**Re: Request for key issues and assessment requirements - State Significant Development proposal - Kings Park Waste Metal Recovery, Processing and Recycling Facility (SSD-7013)**

**Attachment 1 – Matters to be addressed in future EIS for Kings Park Metal Recycling Facility, Tattersall Road, Kings Park (SSD-7013).**

Appendix 1 – Site Plan

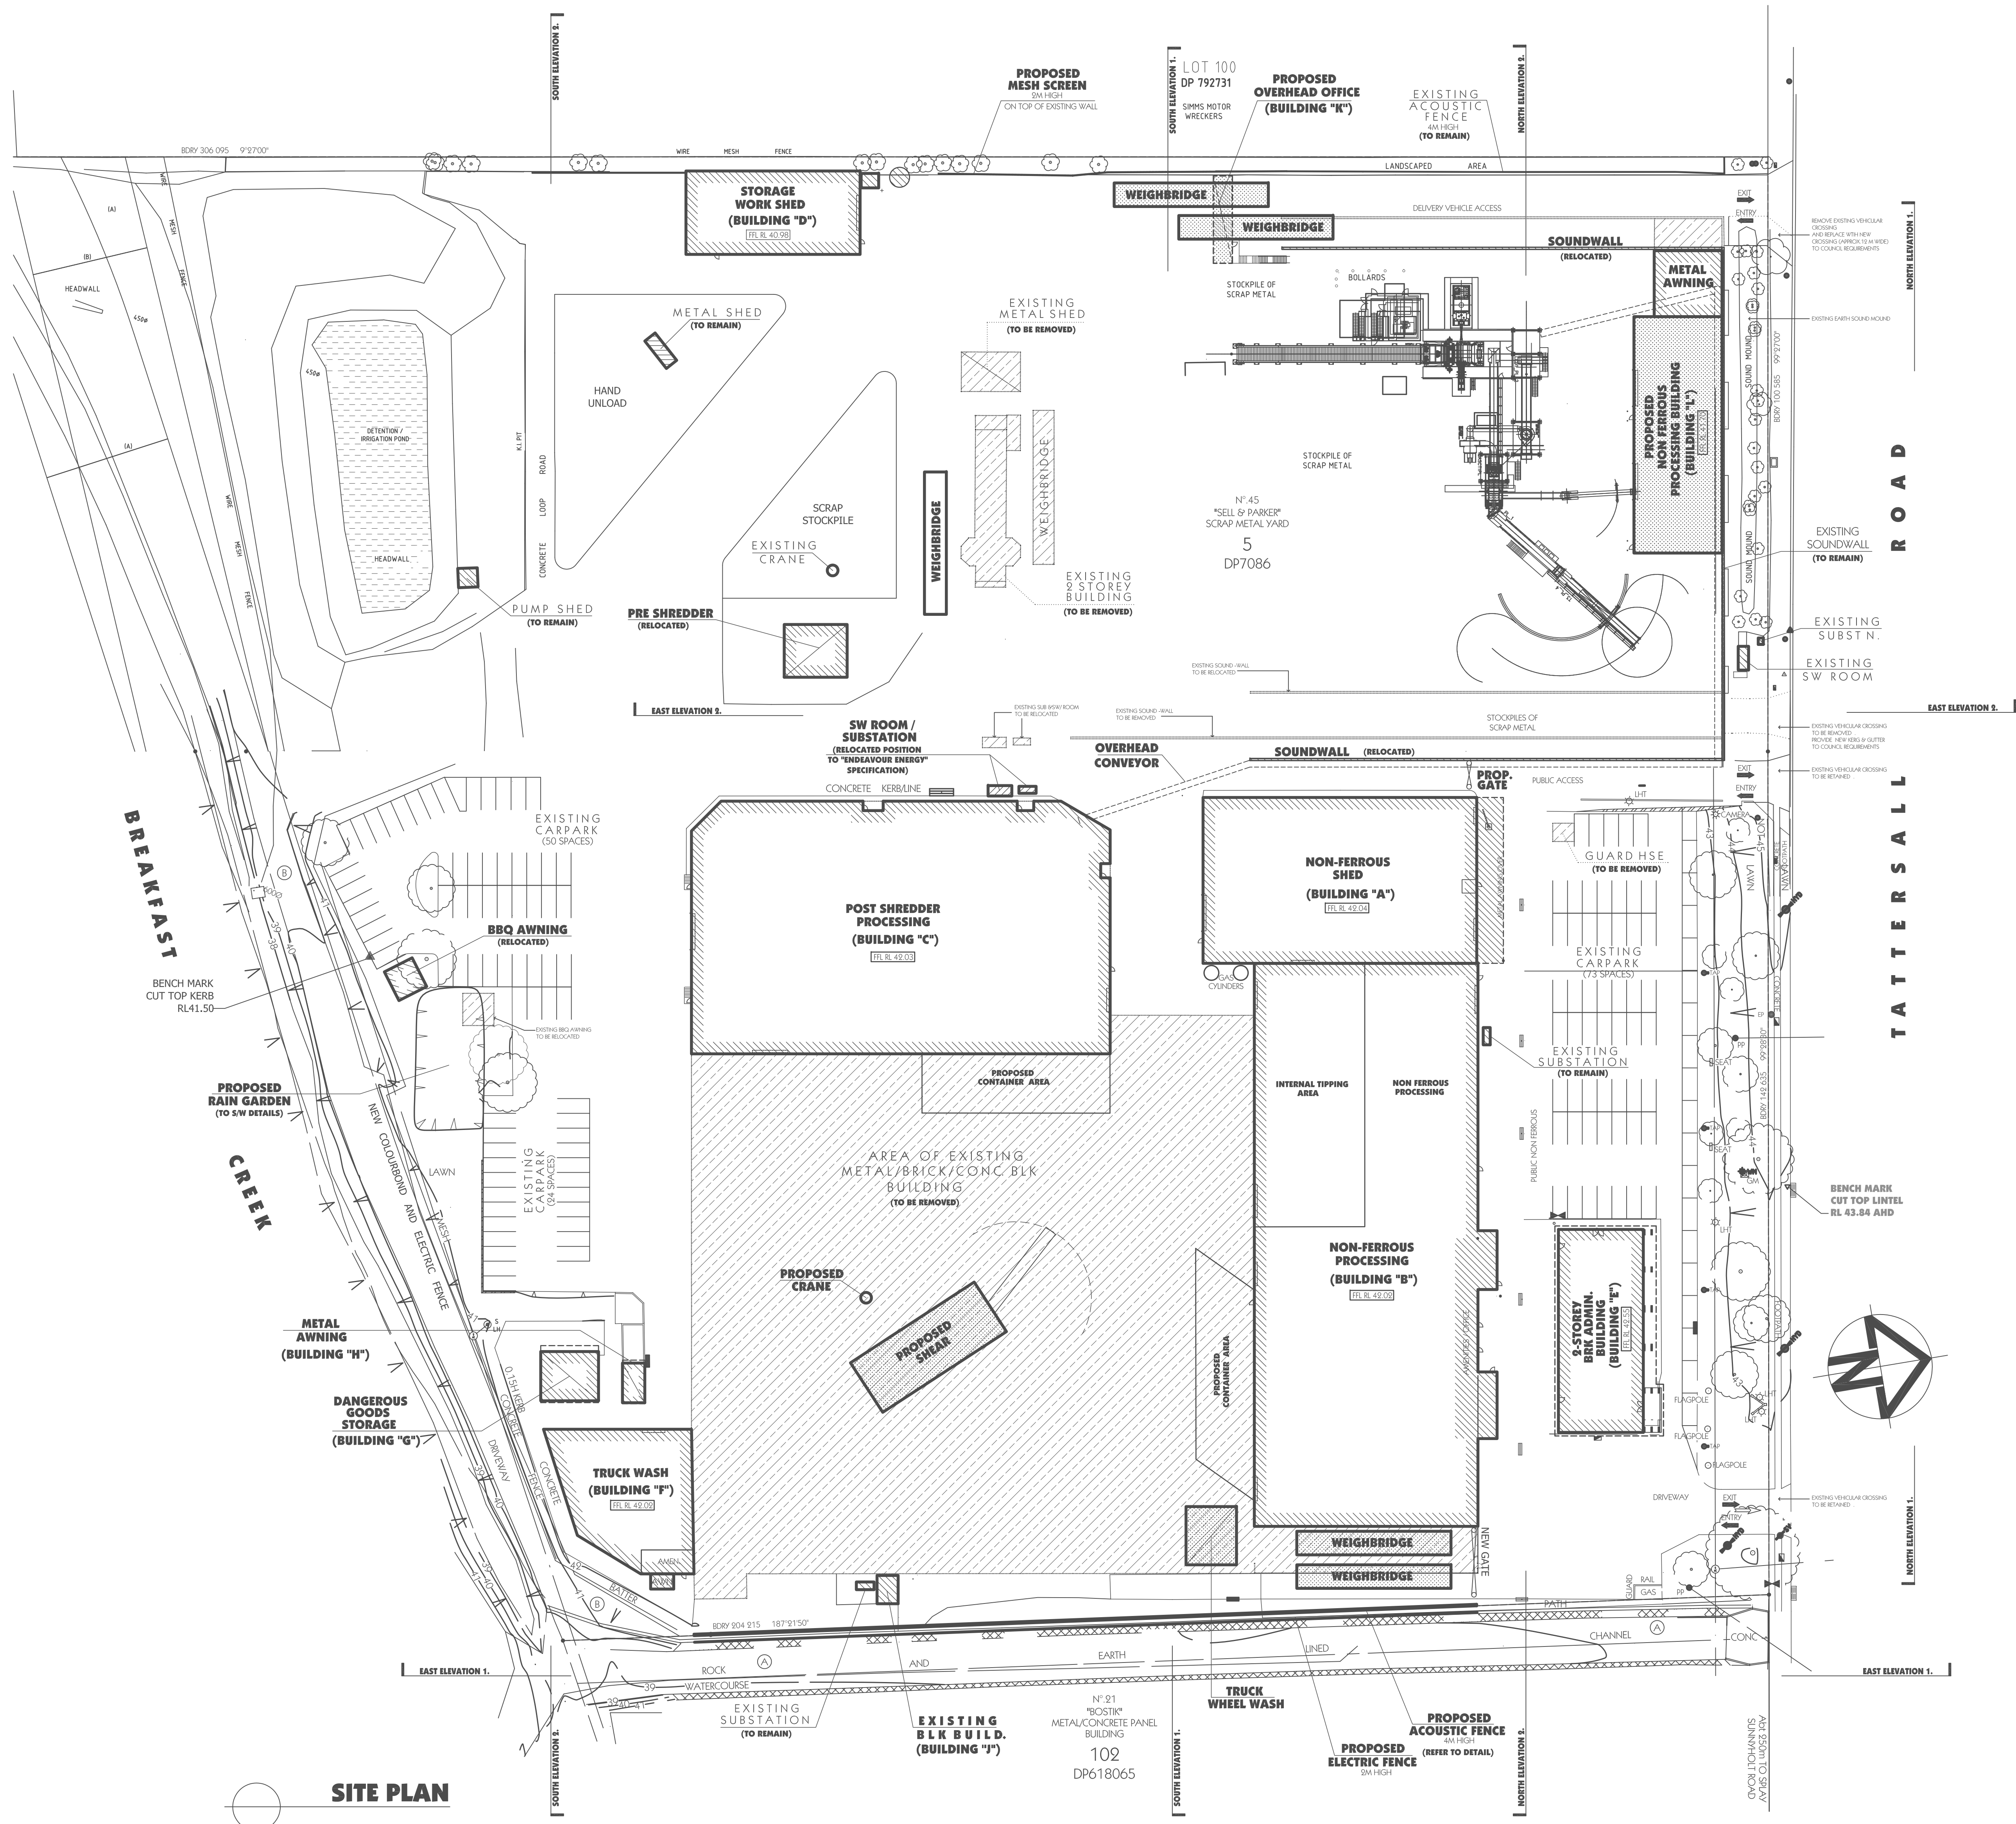
Issue	Matters to be addressed in EIS
Drainage	<p>Compliance with Blacktown Council DCP Part R – WSUD and Integrated Water Cycle Management. In particular the following should be noted:</p> <ul style="list-style-type: none"> <li>• The proposed sound walls and any new internal structures will restrict flood flows and may cause an adverse impact on flood levels or flood impacts to the surrounding properties. An Engineer's Flood Study &amp; Report will be required to certify that the development will not increase flood affection elsewhere, having regard to: <ul style="list-style-type: none"> <li>i) Loss of flood storage. The new dwelling is to be designed to provide flood storage under with sufficient openings to allow floodwaters to enter, store and leave.;</li> <li>ii) Providing pre and post development flood models.</li> <li>iii) Changes in flood levels (maximum 0.01 m), flows, velocities and hazard caused by alteration to flood flows; and</li> <li>iv) Setting floor levels for the new development a minimum of 0.5m above the 1 in 100 year ARI flood levels.</li> </ul> </li> </ul> <p>Note:</p> <ul style="list-style-type: none"> <li>a) No active flow is permitted under the buildings.</li> <li>b) Allow for a minimum Mannings n of 0.1 for the creek, a minimum Mannings n of 0.05 generally and a Mannings n of 0.025 for hard paved areas and roadways.</li> <li>c) Ensure the site has a maximum provisional hazard of 0.4 for pedestrian access and 0.6 for driveways in a 1 in 100 year ARI event;</li> <li>e) The preferred model is TUFLOW, however a hydraulic model such as HEC-RAS can be used to assess flood levels and velocities. The HEC-RAS section locations are to be clearly shown on the plans, maintaining where possible the same location for the pre and post model sections. Show all obstructions and provide ineffective flow areas for sections close to the obstructions.</li> <li>g) An electronic copy of the flood models are to be provided to Council for assessment.</li> <li>h) A separate application to Council may be provide additional information to assist in flood assessment at this site such as catchment boundaries or Areal Laser Survey (for a fee). Email <a href="mailto:Gregory.Hawkes@blacktown.nsw.gov.au">Gregory.Hawkes@blacktown.nsw.gov.au</a> for further information.</li> </ul> <ul style="list-style-type: none"> <li>• On-site detention is to be provided for any redeveloped area in accordance with the requirements of Council's Engineering Guide for Development 2005 based on the <b>Breakfast Creek</b> Catchment.</li> <li>• The development must provide a water quality system to achieve the following pollutant removal targets of Part R of DCP 2006 assessed using MUSIC (a MUSIC model is to be submitted as part of the proposal):</li> </ul> <p><i>Required percentage reductions in post development average annual load</i></p>

<ul data-bbox="454 571 1426 1545" style="list-style-type: none"> <li data-bbox="454 571 1426 1019">• An electronic copy of MUSIC is to be supplied to Council for assessment. The Humeceptors appear to be undersized in MUSIC based on previous information. To support the use of a Humeceptor STC model in MUSIC, the Humes calculator PCSWMM for Humeceptor is to be run. Under step 1 "Project Details" nominate 80% TSS removal. Under Step 4 using the Parramatta North (Masons Hill) Rainfall Data. Under Step 5 Particle Size Distribution highlight "MUSIC" and under Step 6 TSS Loading highlight "Buildup / Washoff". After running the simulation at Step 7, the Step 8 Design Summary STC model is to achieve a minimum of 80% TSS removal. A copy of the "Humeceptor Design Summary" report is to be supplied</li> <li data-bbox="454 1041 1426 1545">• Aim to achieve 80% of non-potable water demand to be met through the reuse of rainwater and/or stormwater assessed using MUSIC. Due the suggested high demand this target may not be achievable however the rainwater tan size needs to be maximised and it is suggested that the treated discharge though the bioretention filter subsoil pipes also be collected subject to fit for purpose The % reuse is to be assessed using the node water balance function within MUSIC using Blacktown's standard rainfall. Non potable water demand is to include landscape watering and toilet/urinal flushing as well as industrial uses. The design rainwater tank volume to be shown on the drainage plans is to be a minimum of 20% greater than the rainwater tank volume used in MUSIC to allow for anaerobic zones and mains make up water levels.</li> </ul>	Pollutant	% post development pollutant reduction targets	Gross Pollutants	90	Total Suspended Solids	85	Total Phosphorous	65	Total Nitrogen	45	Total Hydrocarbons	90
Pollutant	% post development pollutant reduction targets												
Gross Pollutants	90												
Total Suspended Solids	85												
Total Phosphorous	65												
Total Nitrogen	45												
Total Hydrocarbons	90
